CITY OF ALBUQUERQUE

January 11, 2024

Re: ABB ABQ Addition
6625 Bluewater Rd. NW
Traffic Circulation Layout
Engineer's/Architect's Stamp XX-XX-XX (K10-D011)

Based upon the information provided in your submittal received 01-08-24, the above referenced plan cannot be approved for Building Permit until the following comments are addressed:

Conceptual Improvement & Sight Distance Exhibit

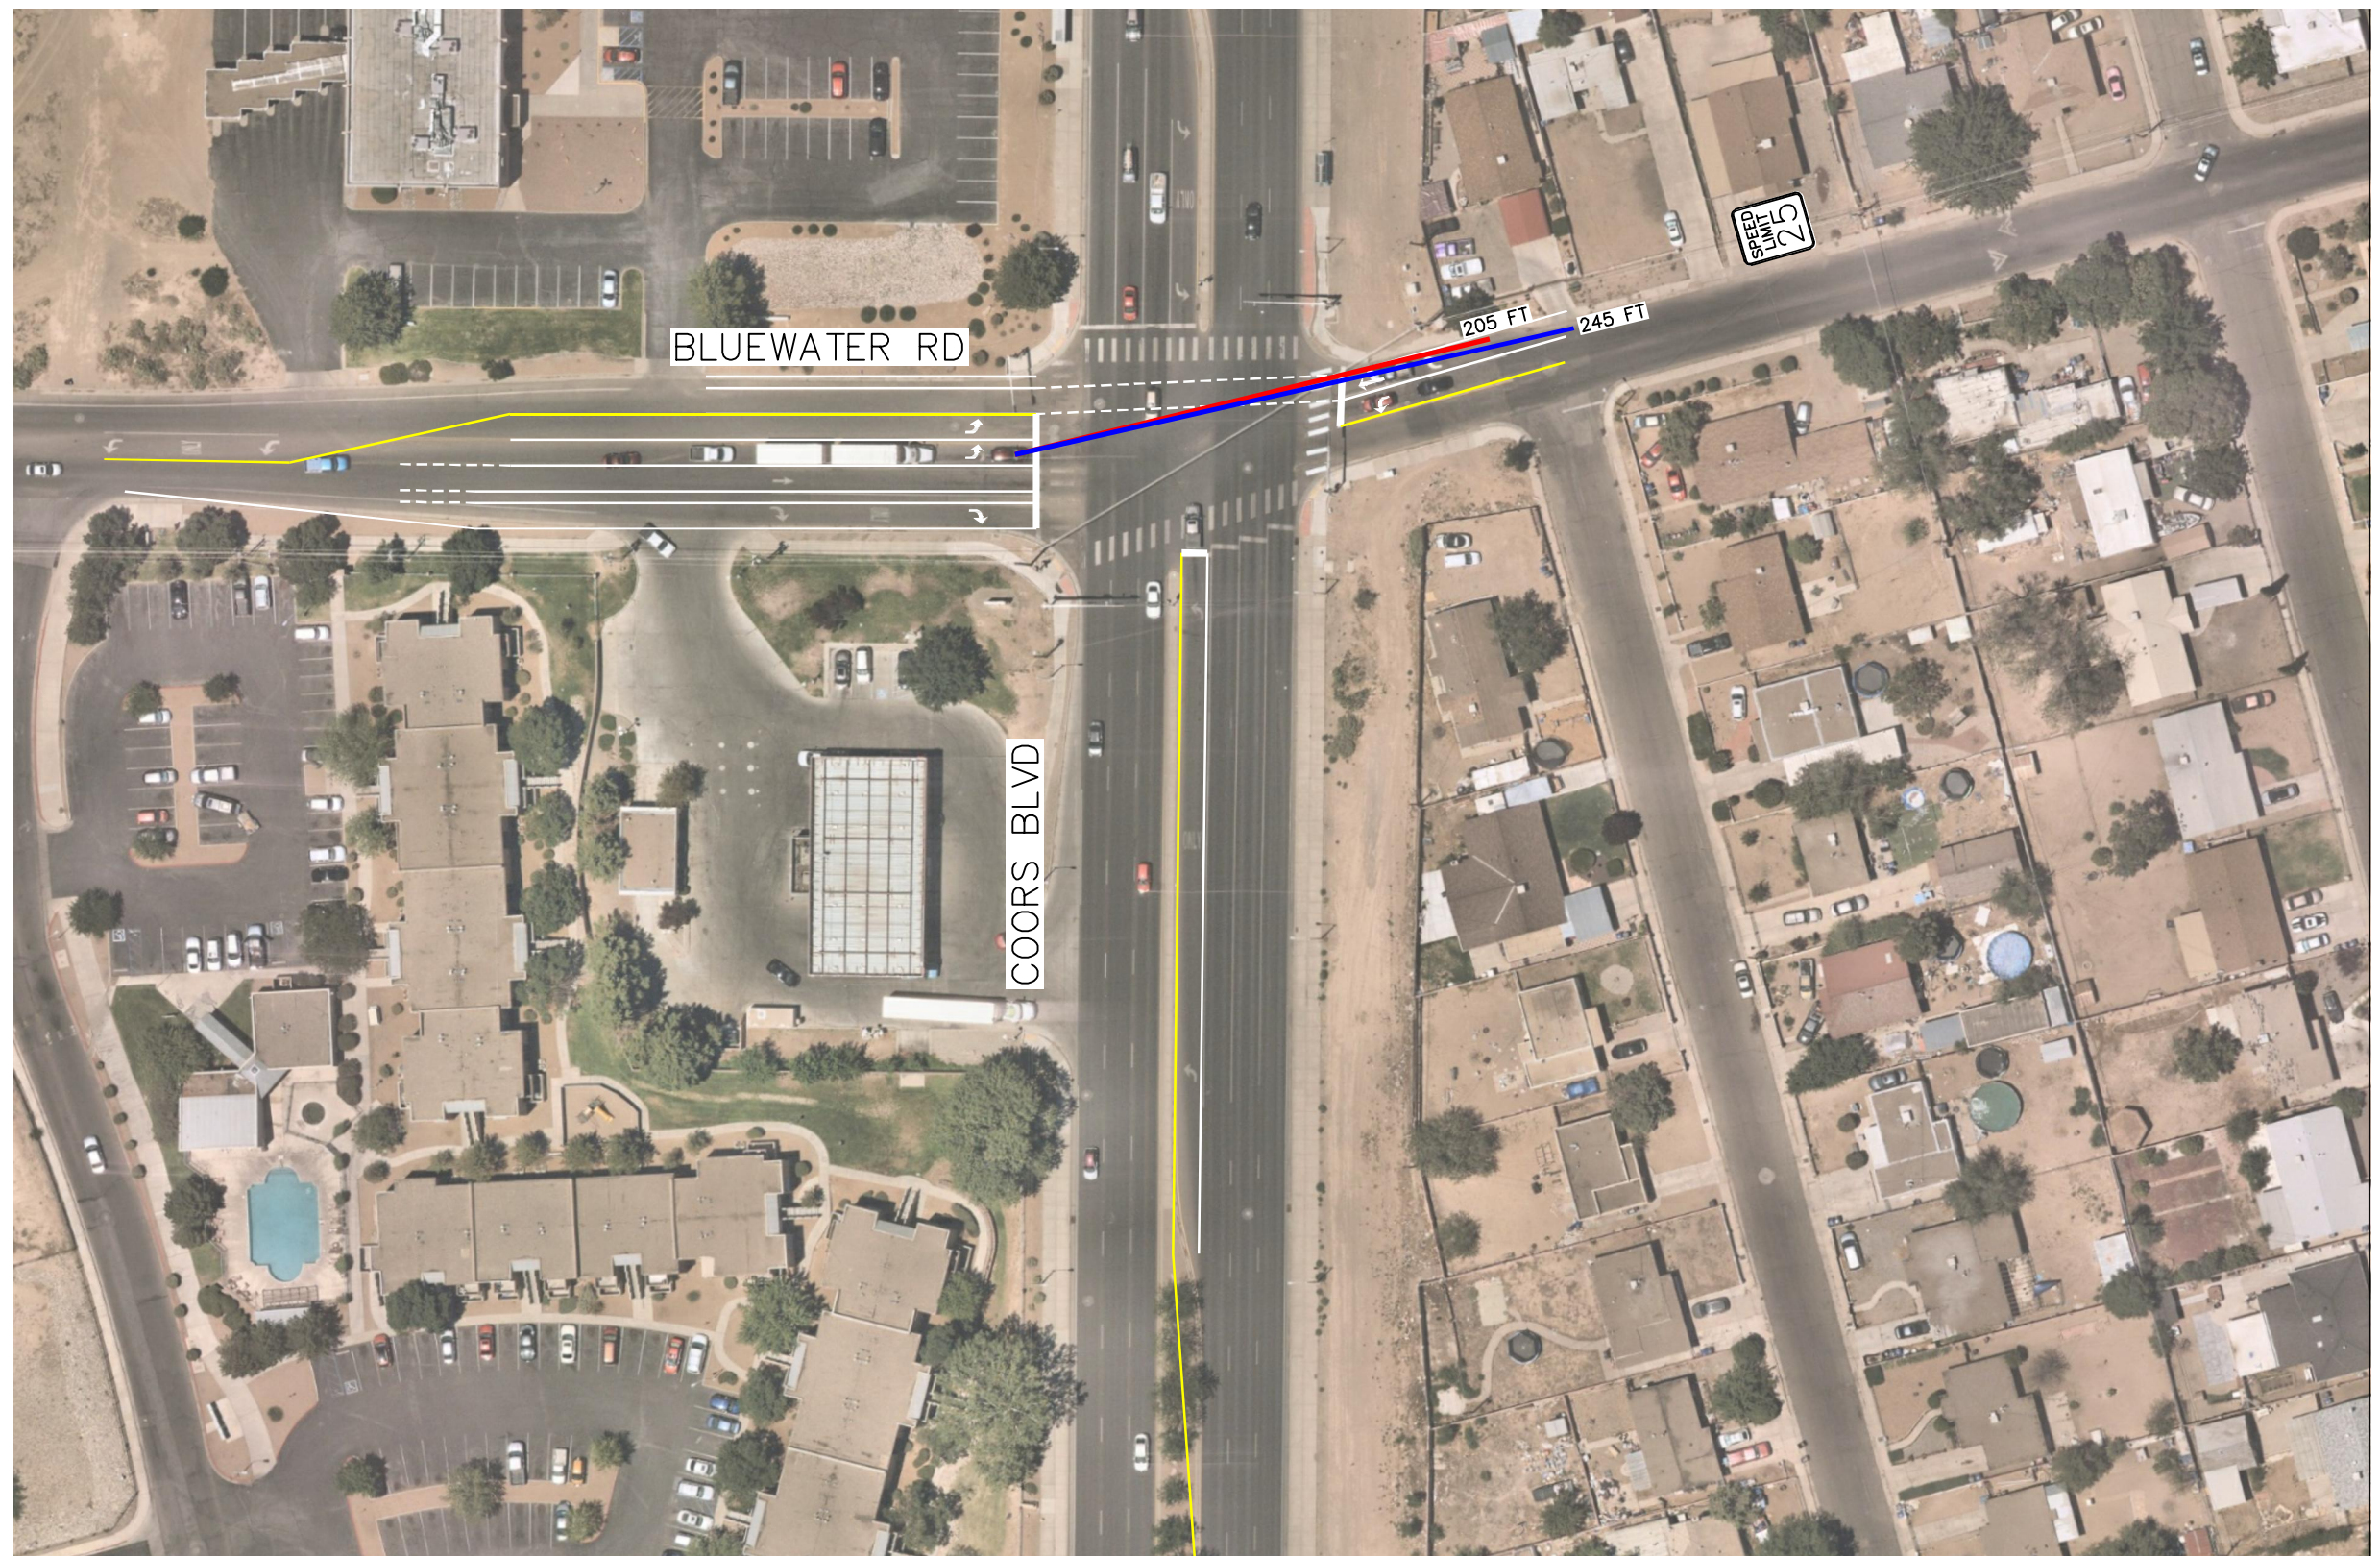
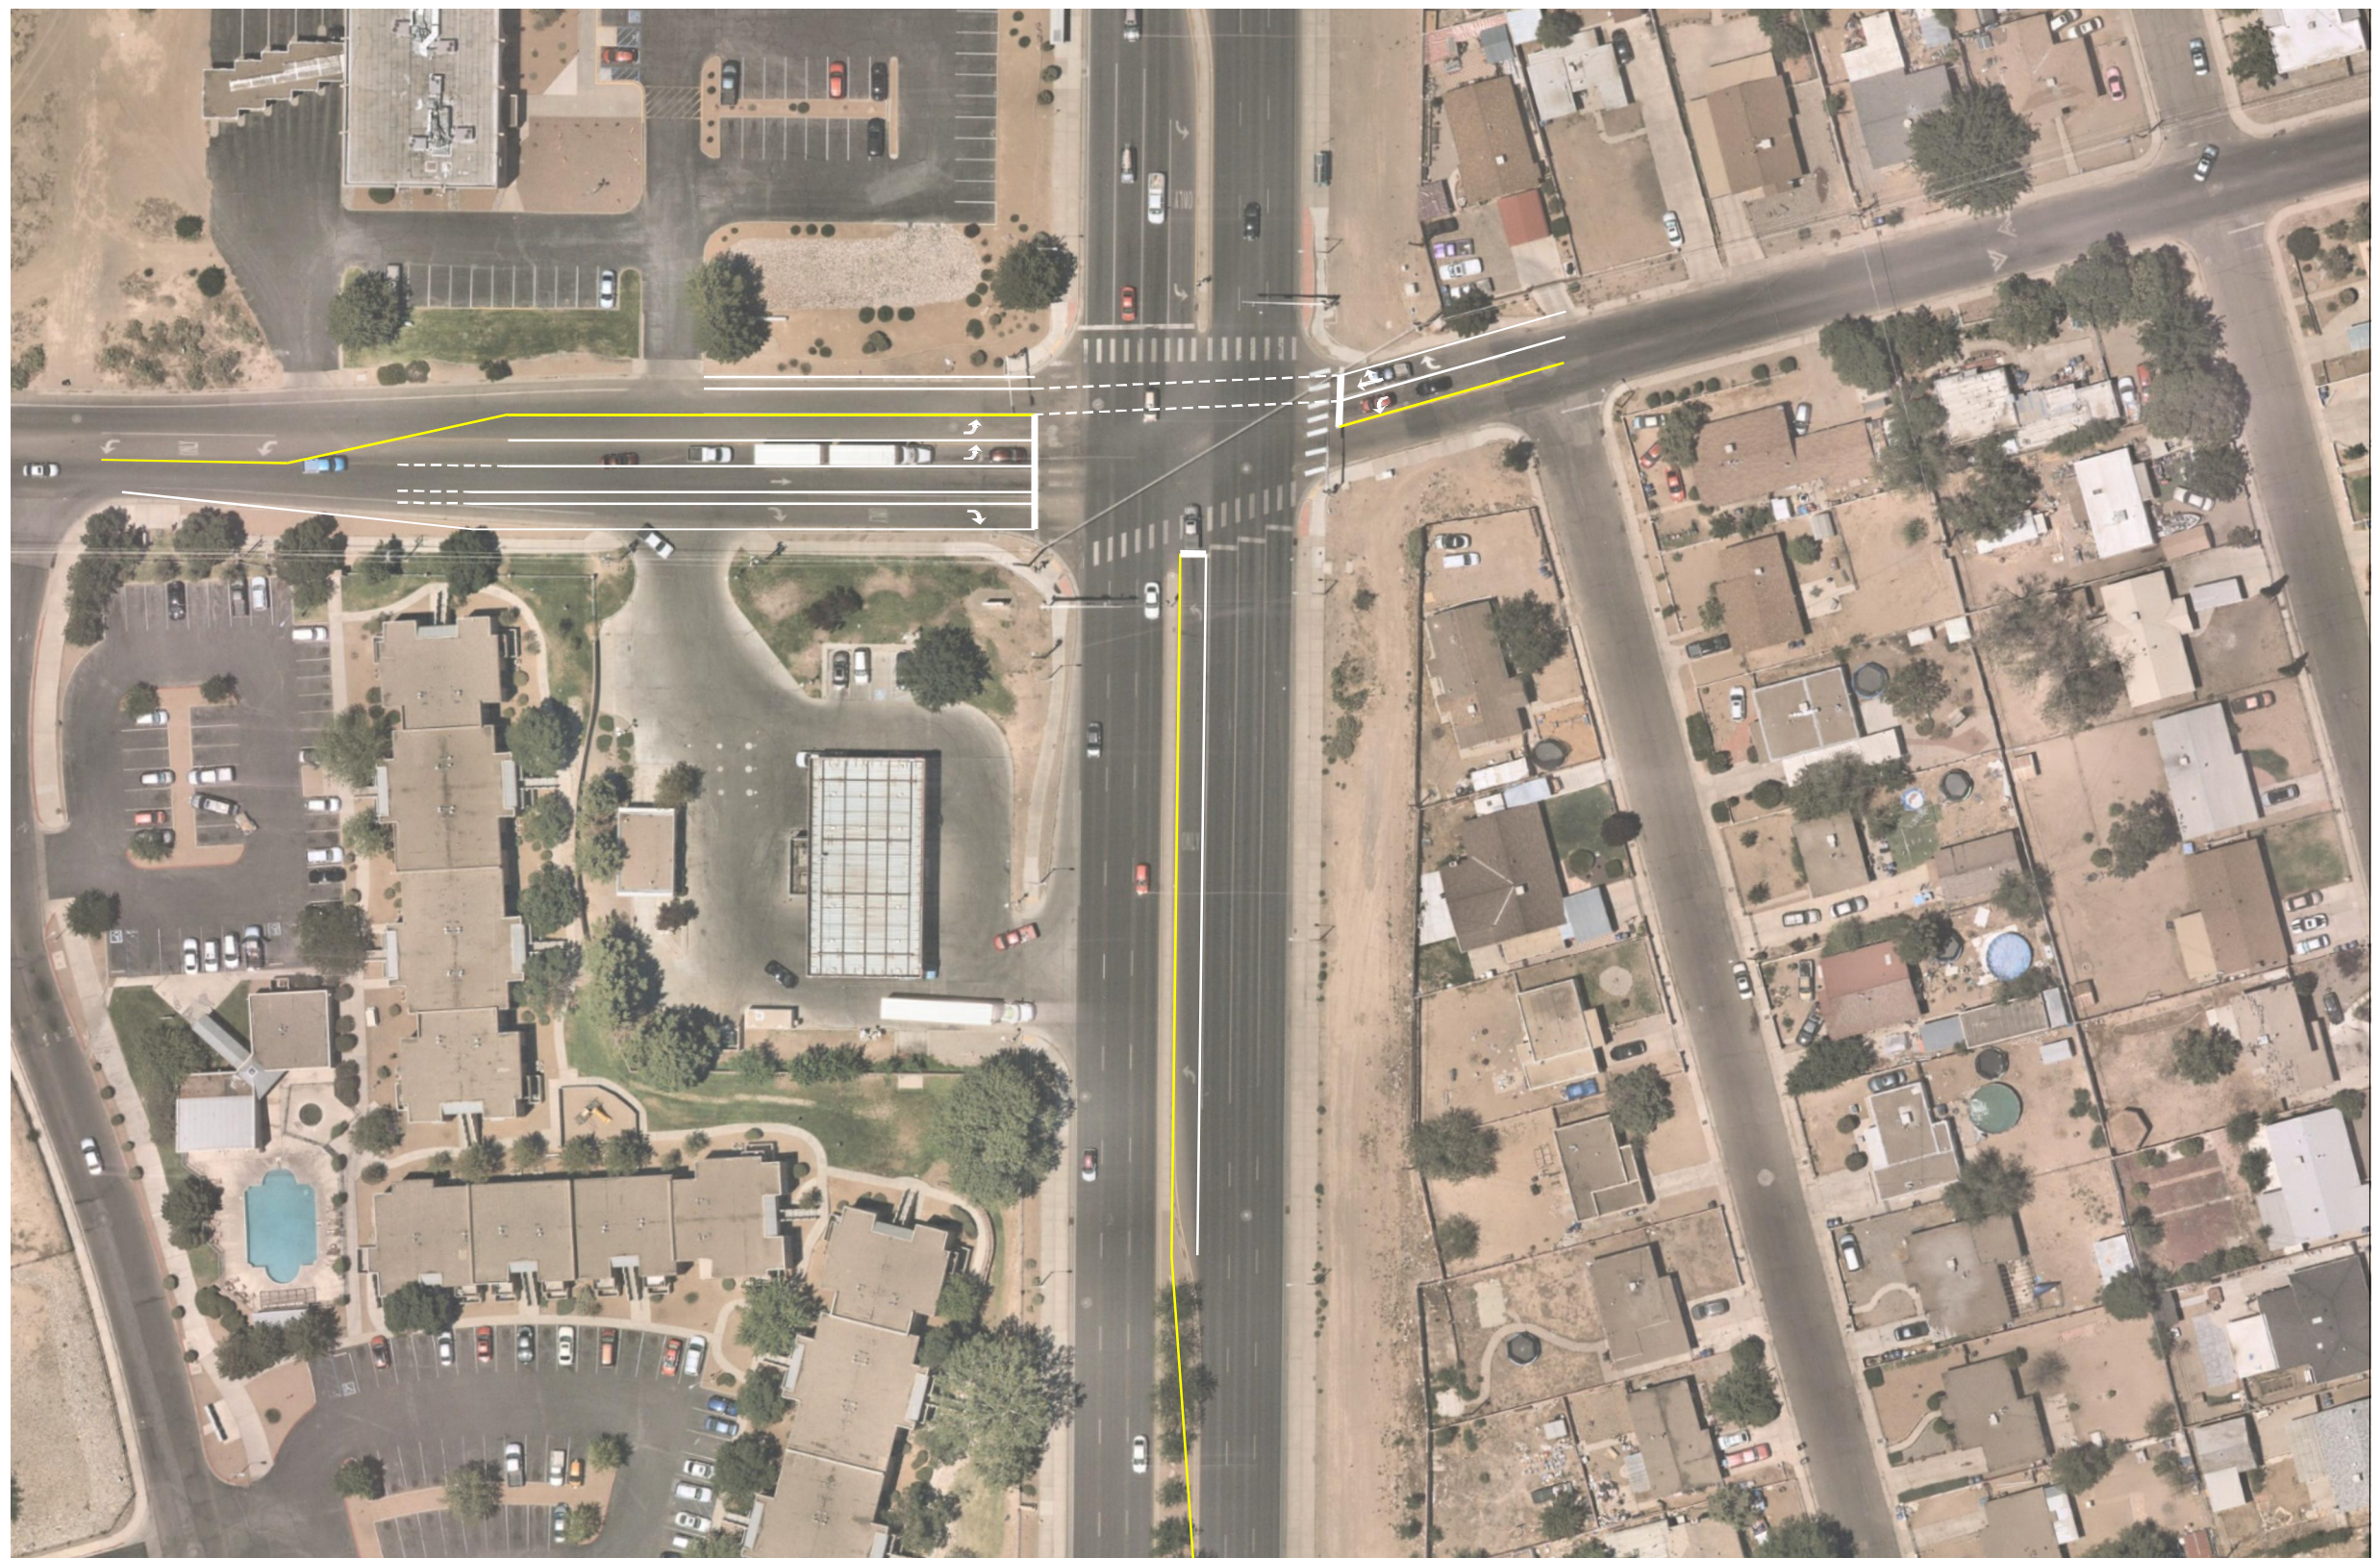
16. Provide a copy of Fire Marshall approval.
17. Please provide a sight distance exhibit
18. Show the Intersection clear sight distance and add the following note to the plan:
"Landscaping and signage will not interfere with clear sight requirements. Therefore, signs, walls, trees, and shrubbery between 3 and 8 feet tall (as measured from the gutter pan) will not be acceptable in the clear sight triangle.
